**METROLINK Railway Order
An Bord Pleanála Oral Hearing**

ABP-314724-22

Client:	Union Investment Real Estate GmbH
Project Title:	Metrolink Oral Hearing
Document Title:	Written Submission – Module 2
Document/Job	JSA 22112 Ref Final

Charlemont LUAS stairs & lift connection 2024

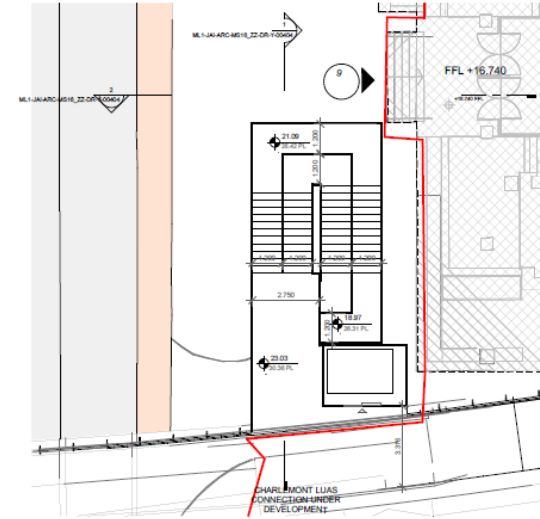
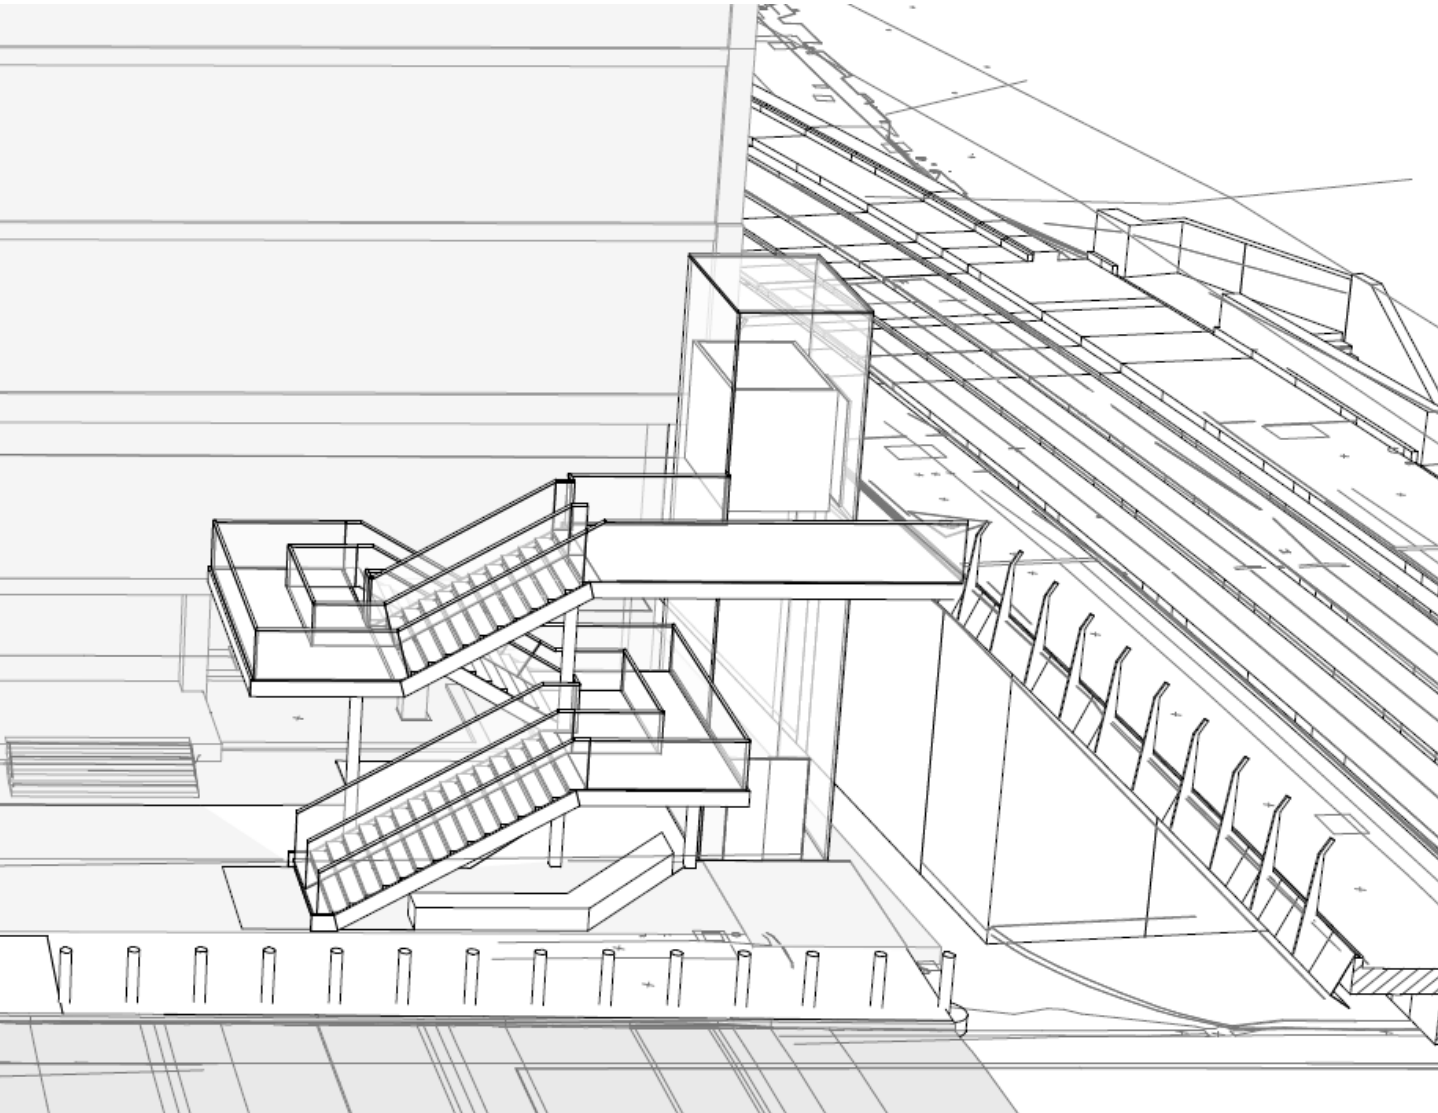
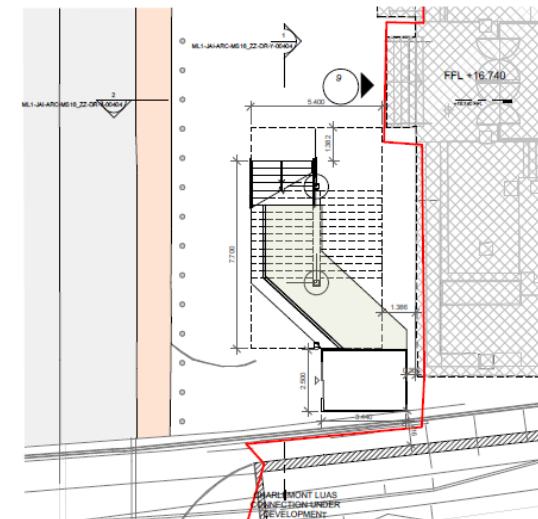
The remainder of this submission relates to the sole issue raised in the submission on the Railway Order application which there appears to no prospect of agreement on with TII, namely the introduction of a proposed stairway and lift structure directly in front of the former Carroll's Building, which forms part of the overall 2 Grand Parade development, and which is a protected structure.

The original submission on behalf of Union Investment on the Railway Order application highlighted that this proposed location for this stairway and lift structure would have a significant and negative impact on the curtilage and front setting of the protected structure facing onto Grand Parade.

It was submitted on behalf of Union Investment that the lift should be relocated to the opposite side of Grand Parade, and that the stairway should be reconfigured to reduce its impact on the protected structure.

It is our opinion that the lift should be relocated away from the front façade of the protected structure to protect its setting. Further consideration should be given to the relocation of the proposed stairway also. The options for relocation of both elements are considered further below.

- As previously noted, the relocation of the proposed lift would help to reduce the significant impact on the protected structure at 2 Grand Parade.
- The lift can be easily accommodated, including queuing space via a slight lengthening of the already proposed cantilevered build-out over the canal which accommodates the drop off for persons with reduced mobility.
- There is already an existing lift to the Luas platform at the south side of Grand Parade, and the relocation sought would provide a lift access along the northern footpath adjacent to the canal which is not truncated (as the footpath is on the southern side).
- The assessment of options undertaken by TII confirmed that the location of the additional lift on the north side of Grand Parade would provide an adequate level of service and capacity.

We request that TII be conditioned to submit a revised design and layout for the interchange between MetroLink and the Charlemont Luas Stop, providing for the relocation of the proposed passenger lift to the north side of Grand Parade and **which would facilitate the re-positioning the stair away from the main entrance and façade of the protected structure.**
